**CENTRAL BEDFORDSHIRE COUNCIL COMMENTS ON DEADLINE 4
SUBMISSIONS**

LONDON LUTON AIRPORT EXPANSION DEVELOPMENT CONSENT ORDER

This document sets out the response of Central Bedfordshire Council (CBC) to various documents submitted at Deadline 4. The comments include input from various technical consultants.

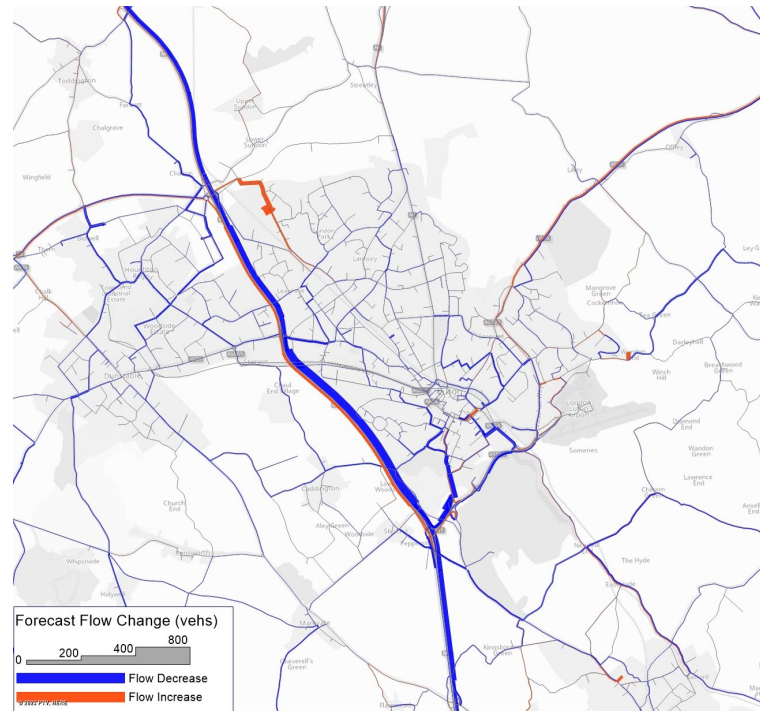
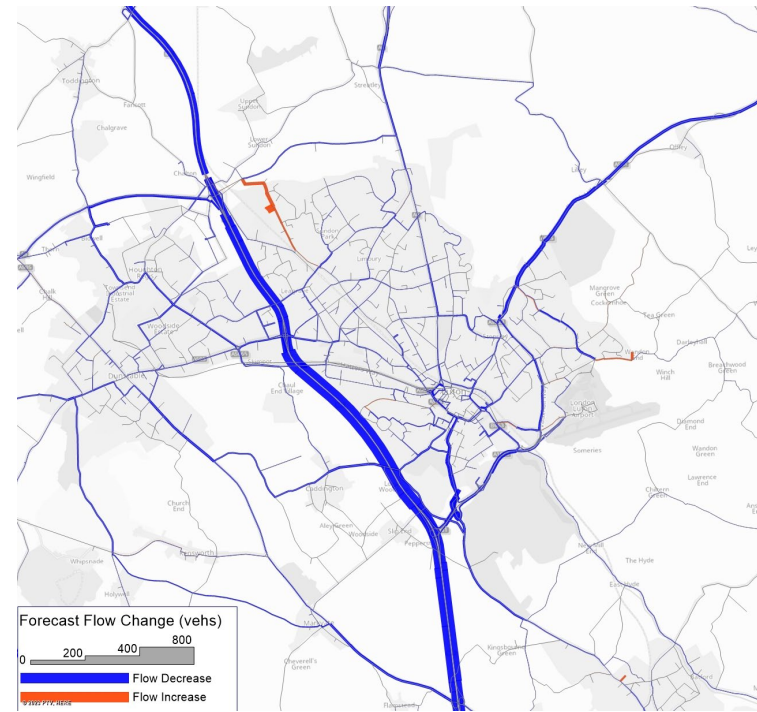
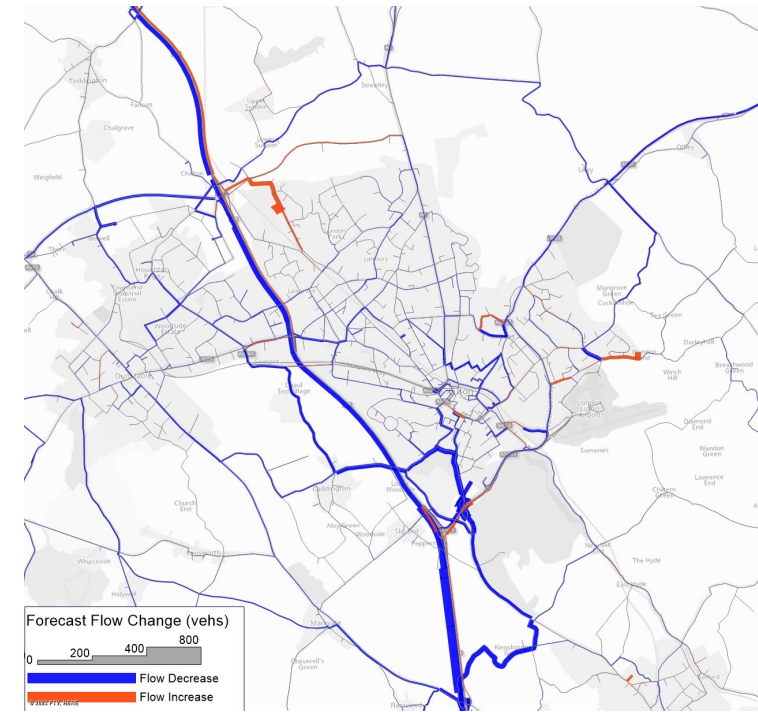
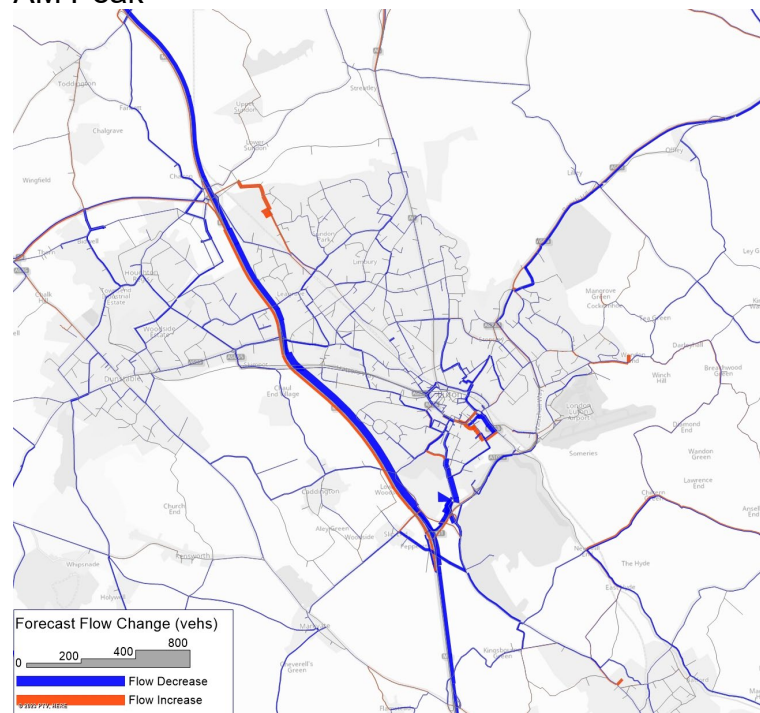
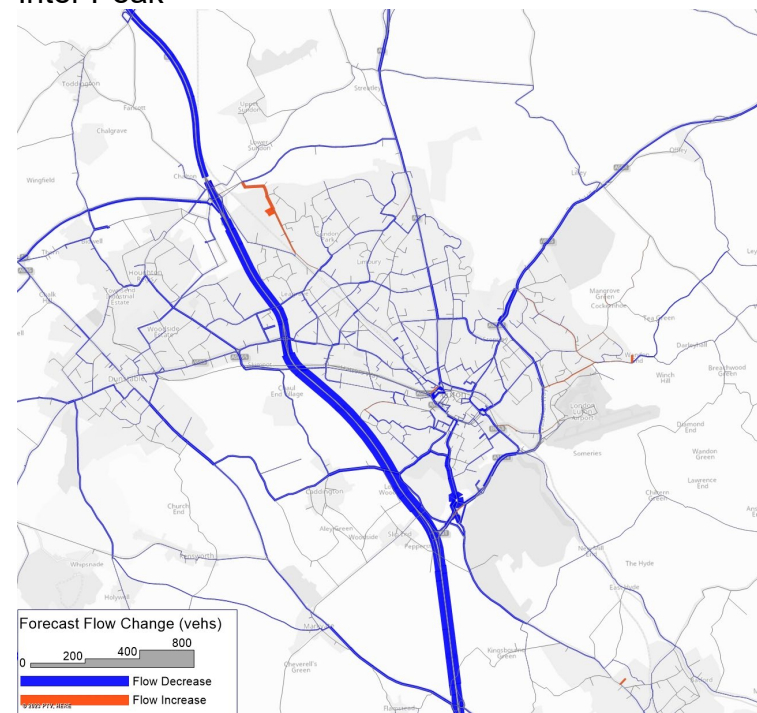
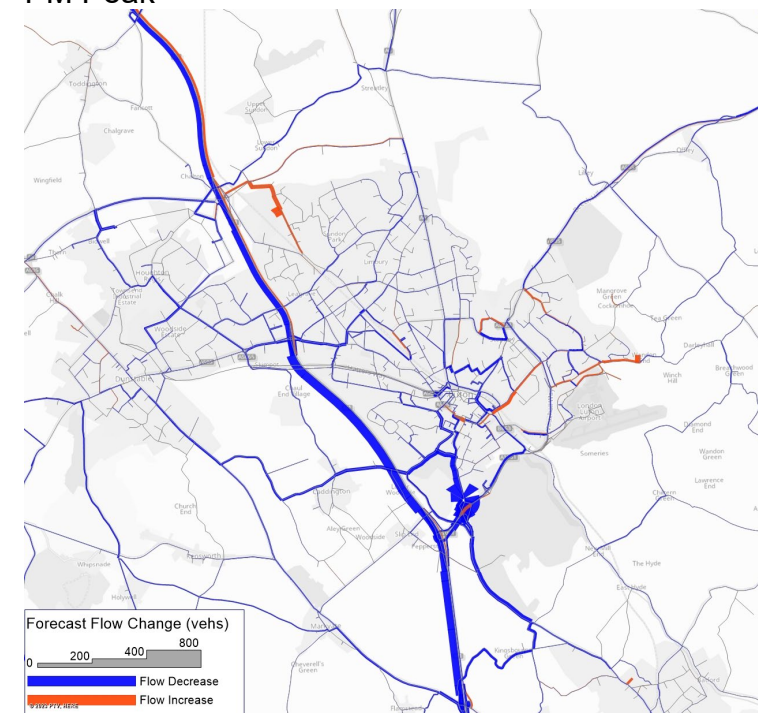
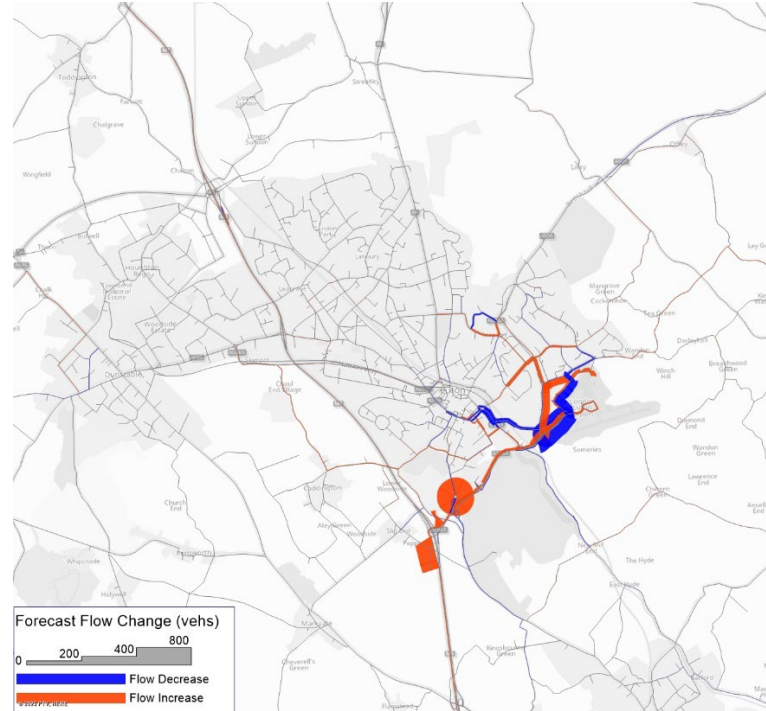
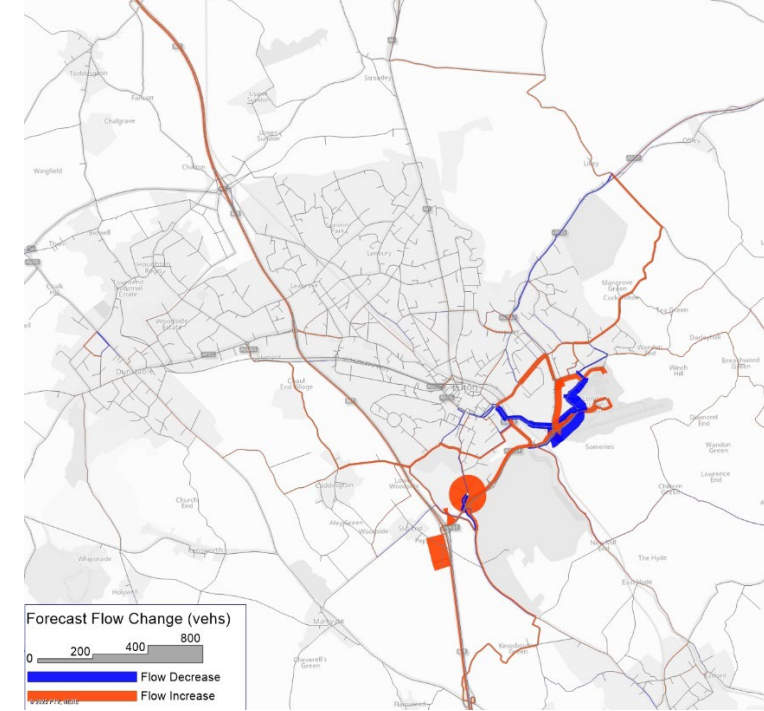
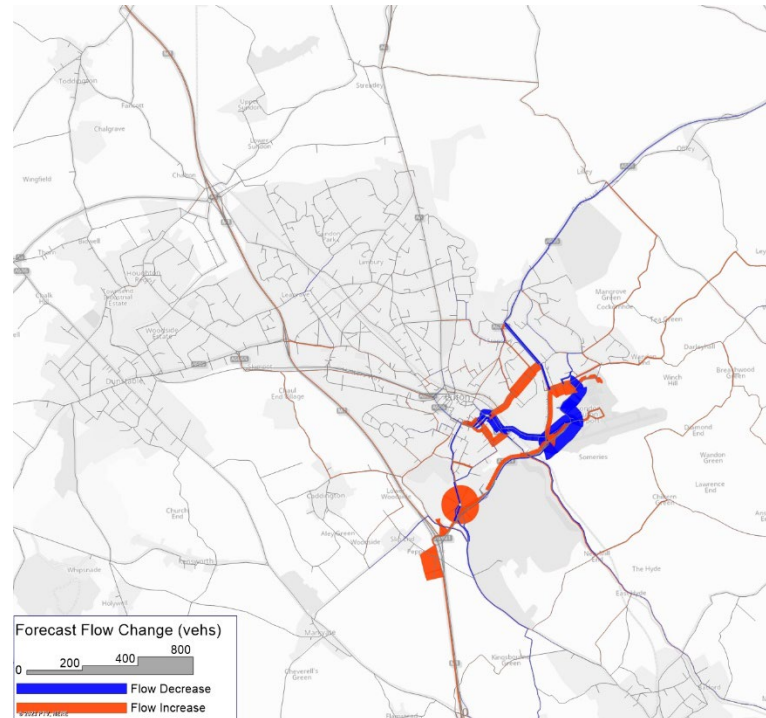
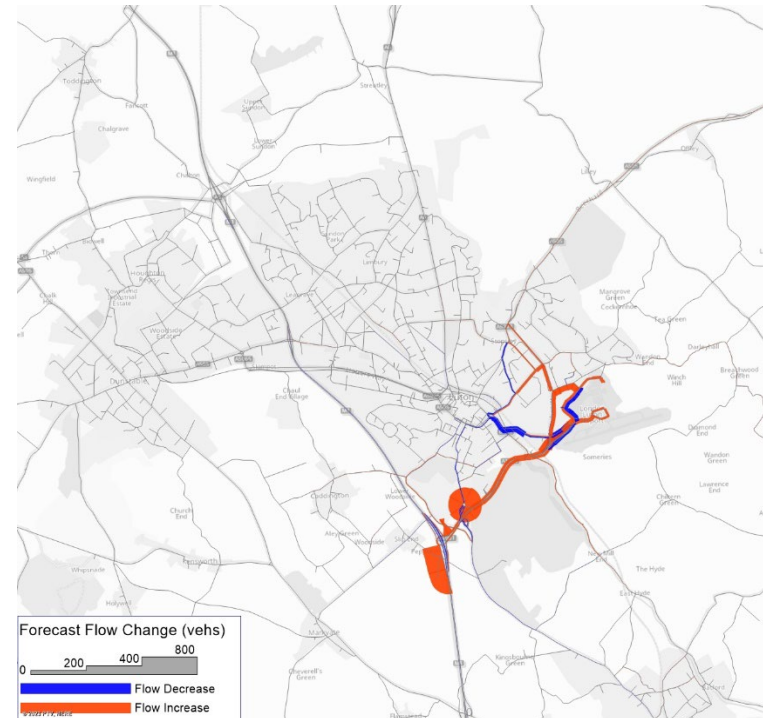
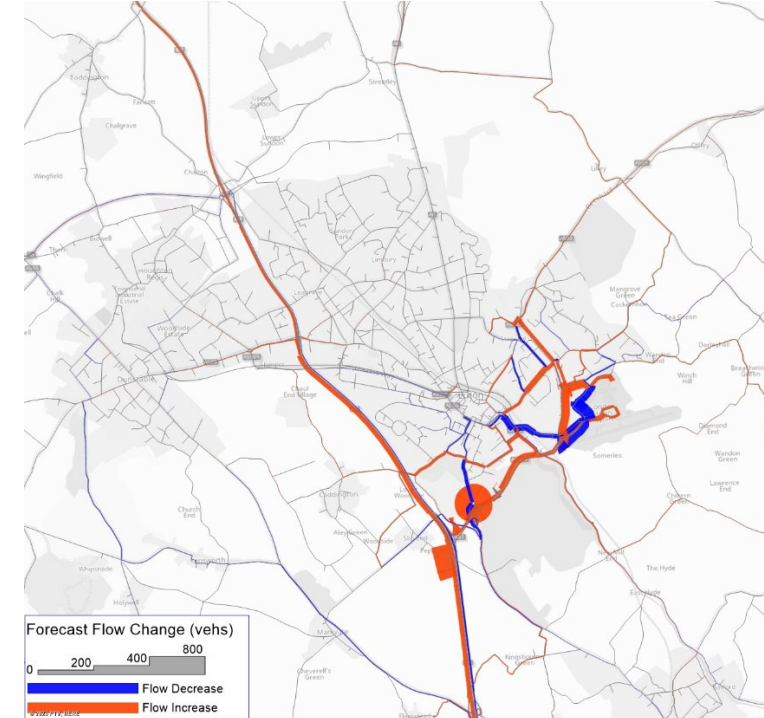
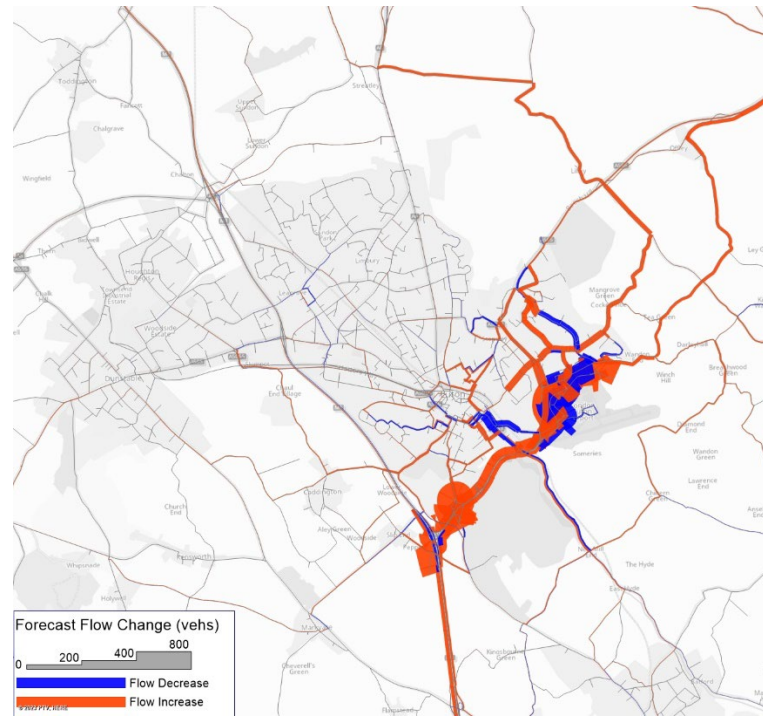
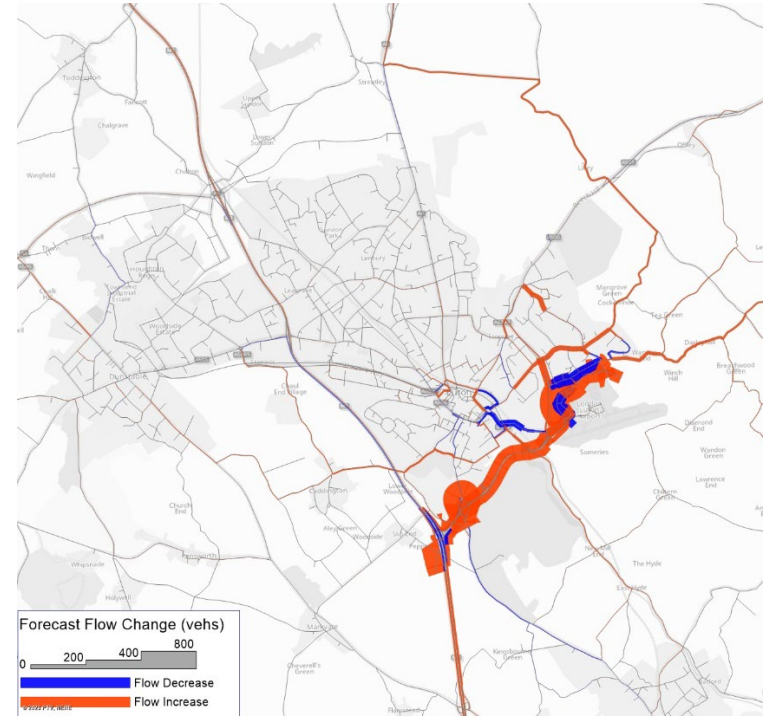
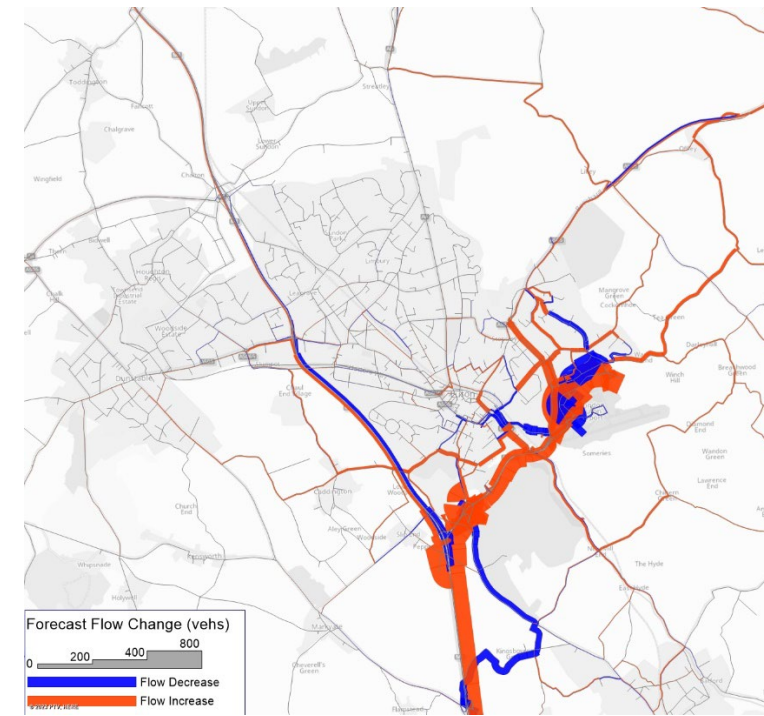
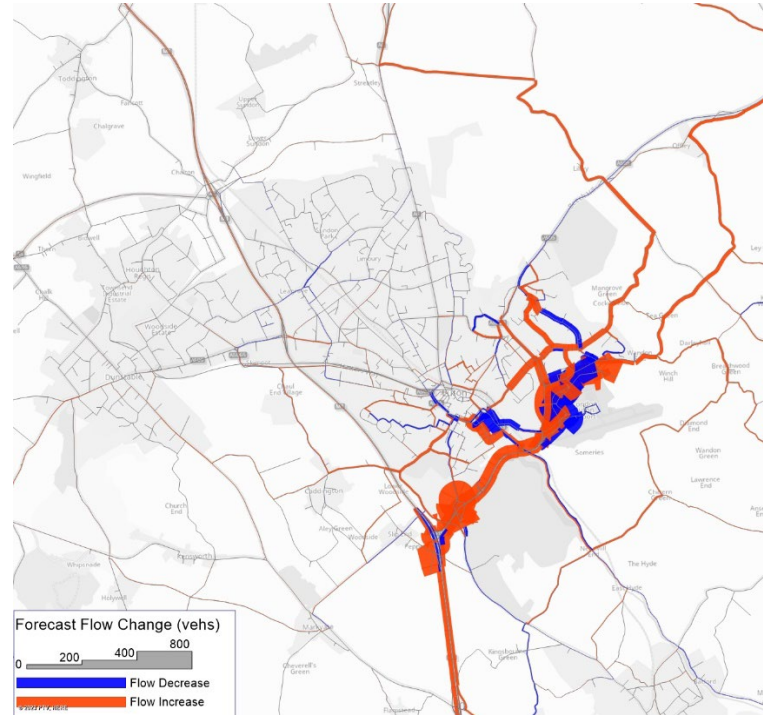
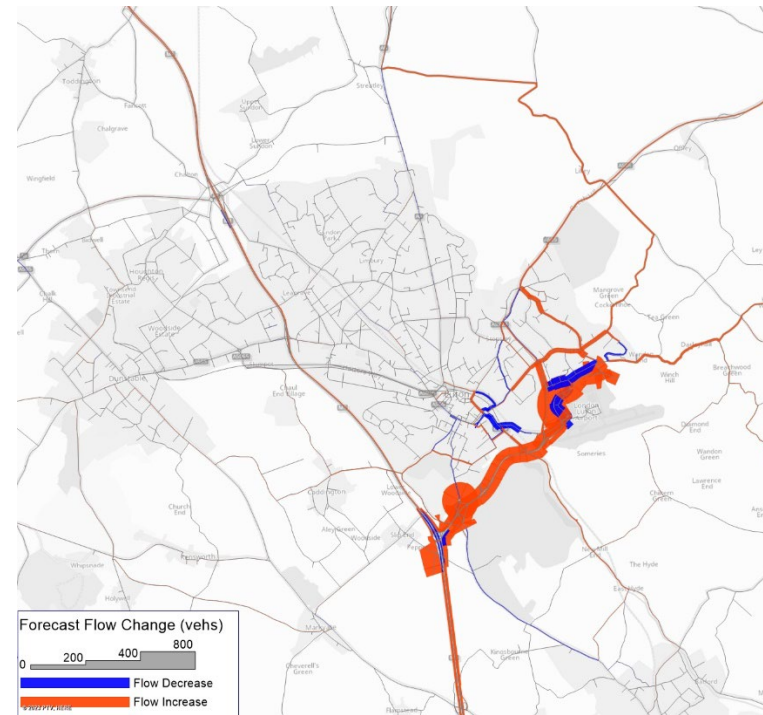
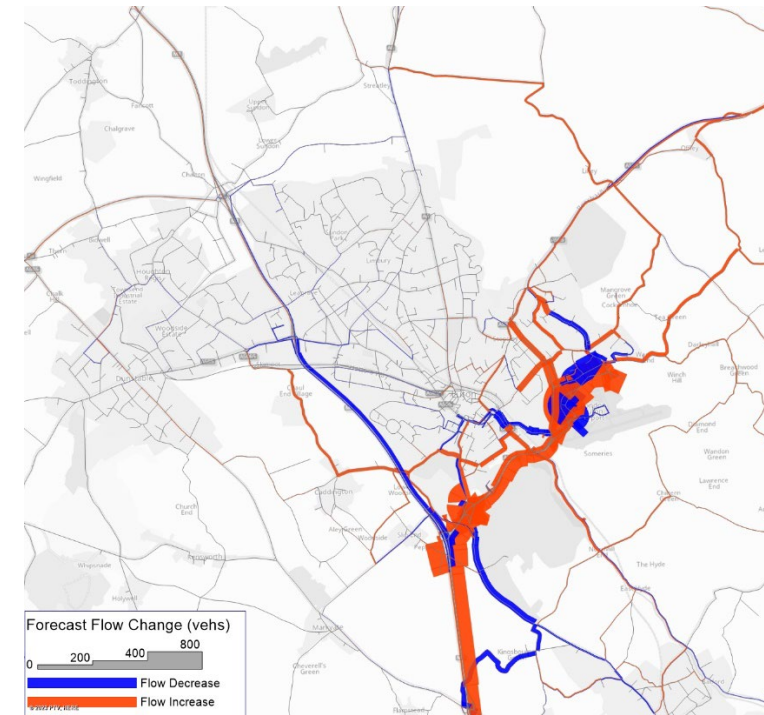
Whilst the comparison exercise carried out and presented is understood to exclude the Smart Motorways scheme, and it is also understood that revised forecasting will be used to inform an update to the Microsimulation modelling of Junction 10, this would also suggest that the remainder of the wider more detailed modelling, as reported within the Transport Assessment, if not updated, would continue to be based upon the previous strategic model outputs which included Smart Motorways in the 2043 forecast. The additional traffic plots provided as figures 3.7-3.12 do provide a degree of reassurance that the distribution of traffic appears not to have changed significantly as a result of the updated modelling, however without numbers assigned to the various routes it is not possible to fully determine the level of change.

With regards to areas where CBC have previously raised concern, it appears that in both the 2039 and 2043 forecast PM peak models there is no growth in traffic on the M1 north of J10 in the updated modelling (compared to the increases forecast in the previous model), which would suggest that this strategic traffic is getting displaced elsewhere within the network. It also appears that the increase in the level of traffic routing via Caddington following development, is higher in the updated modelling (the 2043 assessment).

As detailed above, the information provided in Figures 2.7 to 3.12 does provide a helpful level of additional information, it is however difficult to fully identify the net changes between the two models without numbers assigned to the modelled links. CBC would therefore request a further set of difference plots with number assigned to links within CBCs network or tabulated flows for those links, and / or a plot showing the net difference between the two models (previous and updated). Following receipt of this information, and clarification of the above points, CBC would be in a position to comment more fully upon

this matter, including whether there would be a need to update any off-site junction modelling where flows are predicted to be higher in the updated modelling (as is potentially the case in Caddington).
